Addendum No. 1

RE: Contract ID C203404

Bridge #35 On US-70 Across Ward Creek And Bridge #39

On US-70 Across Oyster Creek

REVISIONS						SHEET NO.
NO.	BY:	DATE:	NO.	BY:	DATE:	TOTAL SHEETS
1			3			5-2
2			4			49

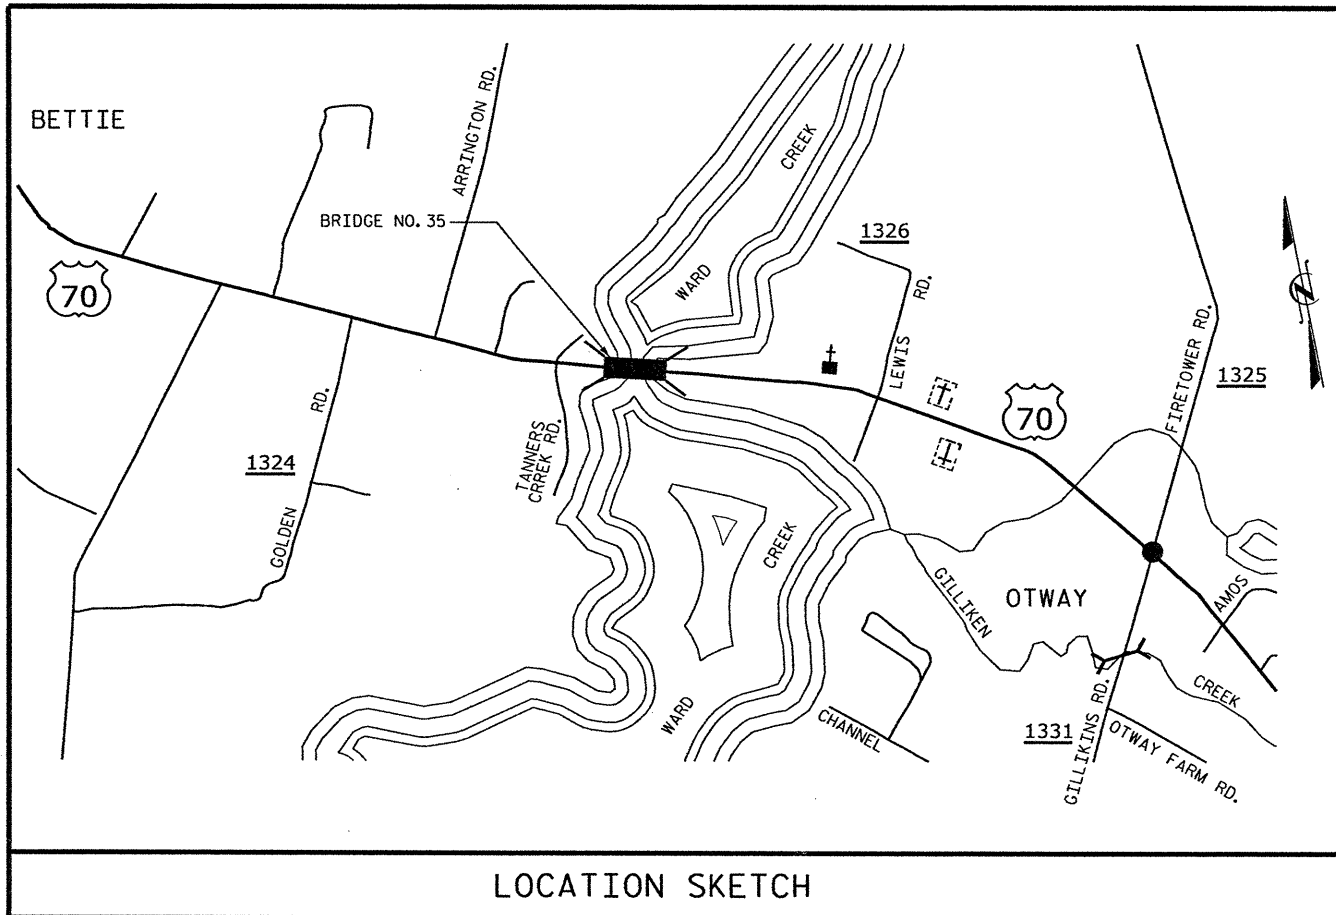
- On Sheet No.S-2: the 11th note in the first column of the general notes was revised to require epoxy coated bar supports in the barrier rail.
- On Sheet No.S-8: Ten additional pairs of required 2 ½" dowel holes were added to be in agreement with the dowel placement shown on sheet S-13.
- On Sheet No.S-9: The following two notes were added:

STATE OF NORTH CAROLINA DEPARTMENT OF TRANSPORTATION RALEIGH					
STANDARD 3'-0" X 1'-9" PRESTRESSED CONCRETE CORED SLAB UNIT 90° SKEW					
REVISIONS					
NO.	BY:	DATE:	NO.	BY:	DATE:
1			3		
2			4

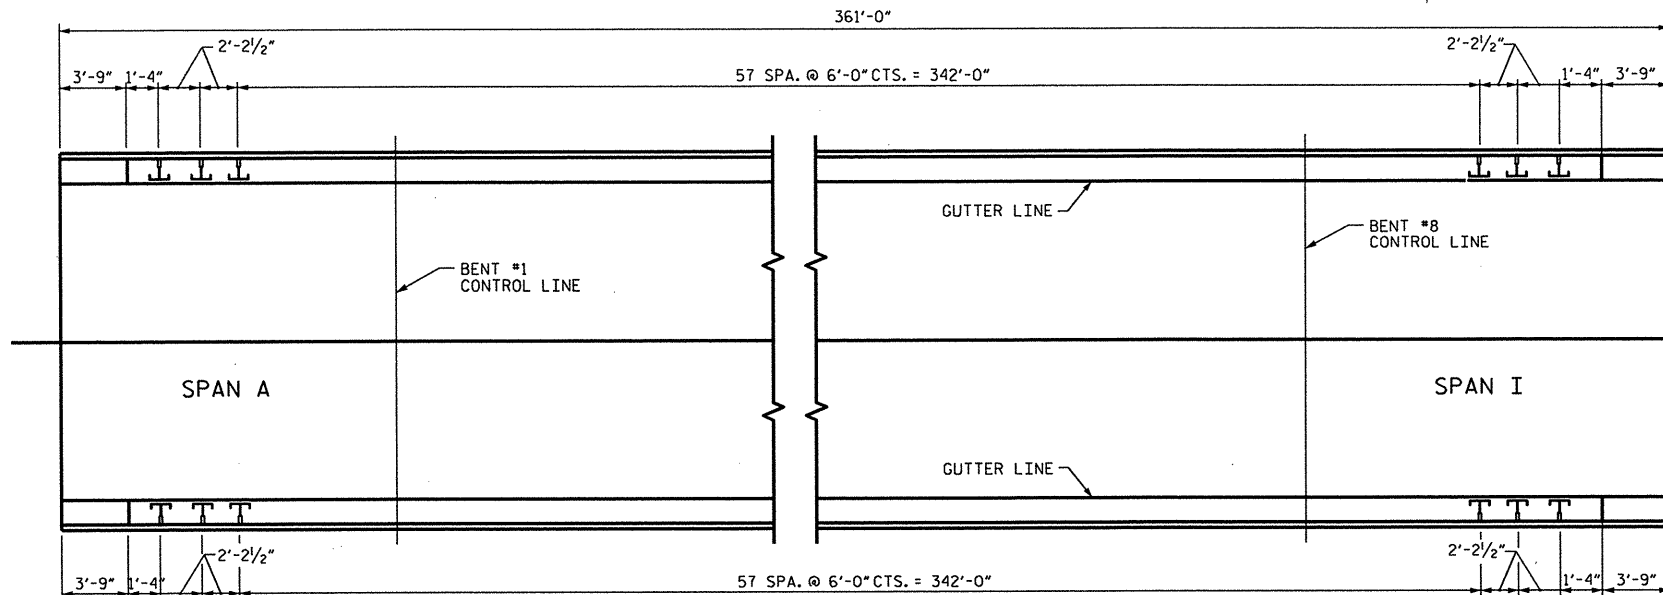
"PRESTRESSED CONCRETE CORED SLAB UNITS ARE DESIGNED FOR 0 PSI TENSION IN THE PRECOMPRESSED TENSILE ZONE UNDER ALL LOADING CONDITIONS".

"PRESTRESSED CONCRETE CORED SLAB UNITS SHALL CONTAIN CALCIUM NITRITE CORROSION INHIBITOR IN ACCORDANCE WITH THE STANDARD SPECIFICATIONS."

REVISIONS						SHEET NO.
NO.	BY	DATE	NO.	BY	DATE	S-27
1			3			TOTAL SHEETS
2			4			49

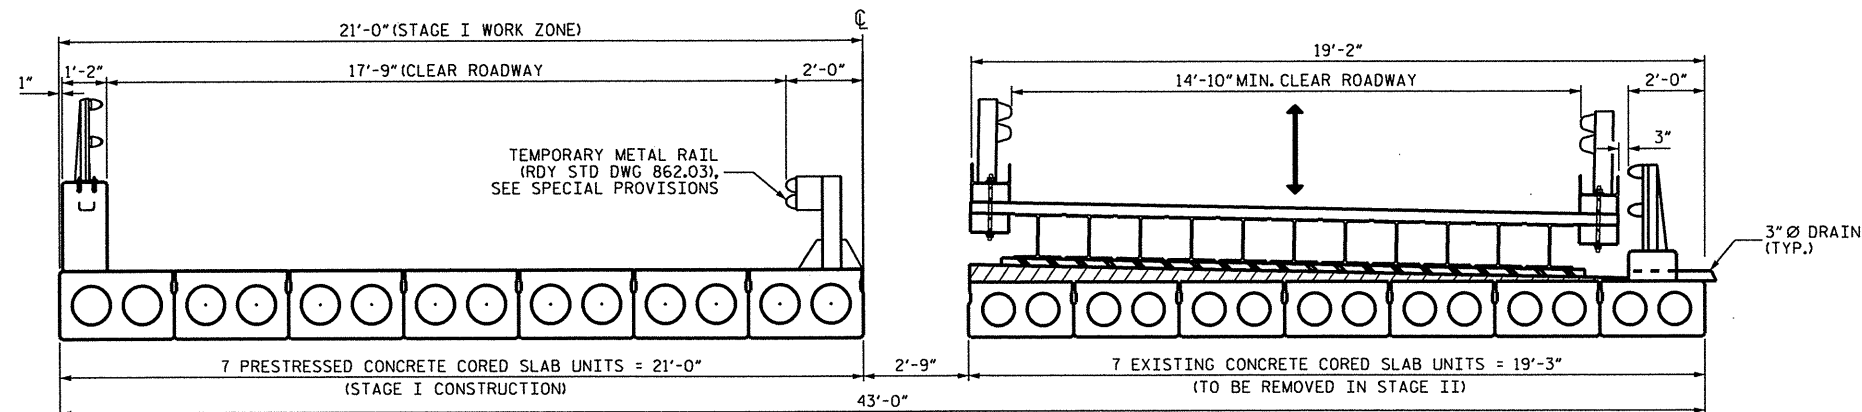
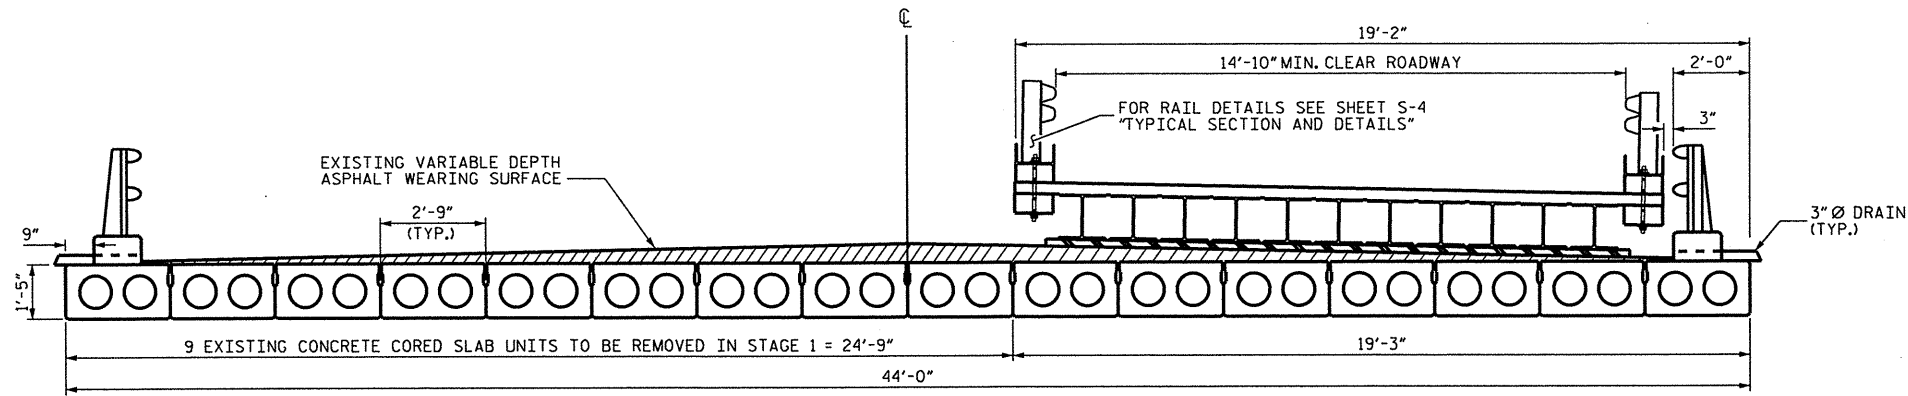
- On Sheet No.S-27: the 11th note in the first column of the general notes was revised to require epoxy coated bar supports in the barrier rail.
- On Sheet No.S-33: Ten additional pairs of required 2 ½" dowel holes were added to be in agreement with the dowel placement shown on sheet S-38.
- On Sheet No.S-34: The following two notes were added:

STATE OF NORTH CAROLINA DEPARTMENT OF TRANSPORTATION RALEIGH					
STANDARD 3'-0" X 1'-9" PRESTRESSED CONCRETE CORED SLAB UNIT 90° SKEW					
REVISIONS					SHEET NO.
NO.	BY:	DATE:	NO.	BY:	DATE:
1			3		
2			4

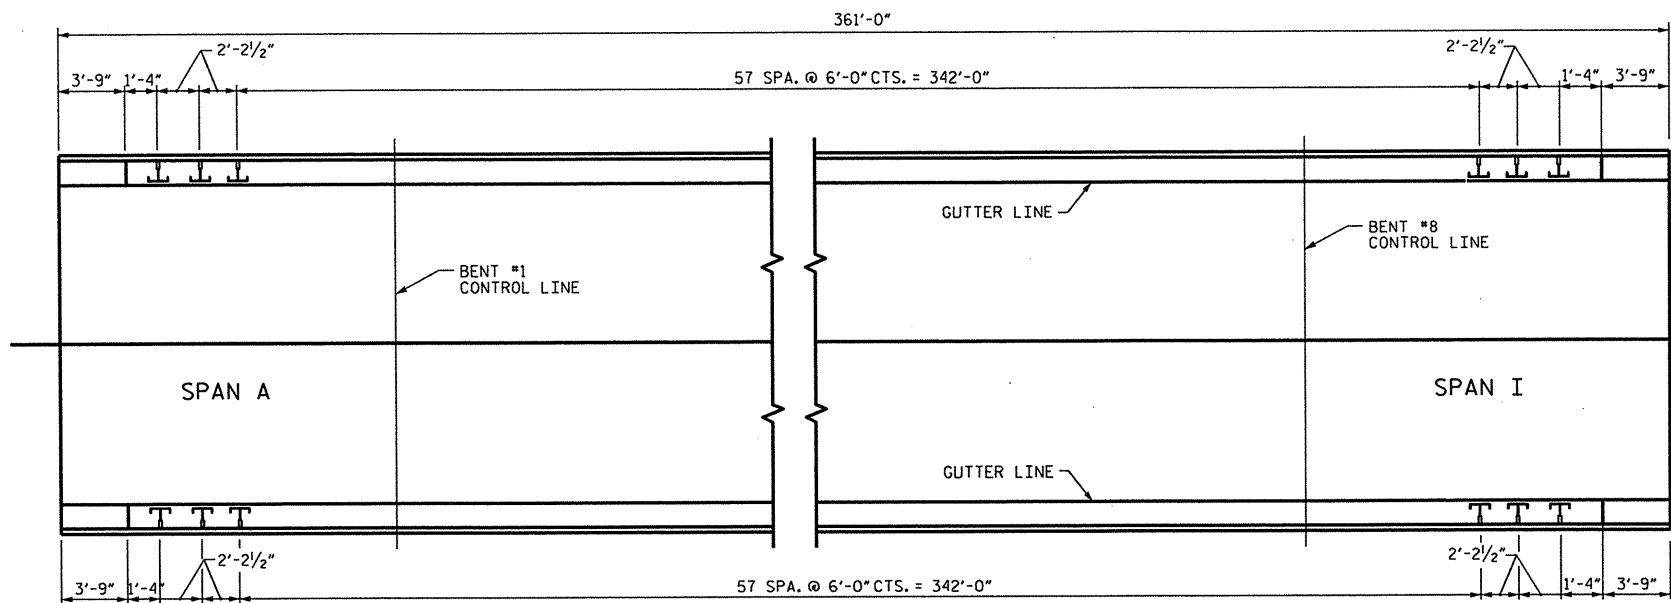
“PRESTRESSED CONCRETE CORED SLAB UNITS ARE DESIGNED FOR 0 PSI TENSION IN THE PRECOMPRESSED TENSILE ZONE UNDER ALL LOADING CONDITIONS”.

“PRESTRESSED CONCRETE CORED SLAB UNITS SHALL CONTAIN CALCIUM NITRITE CORROSION INHIBITOR IN ACCORDANCE WITH THE STANDARD SPECIFICATIONS.”
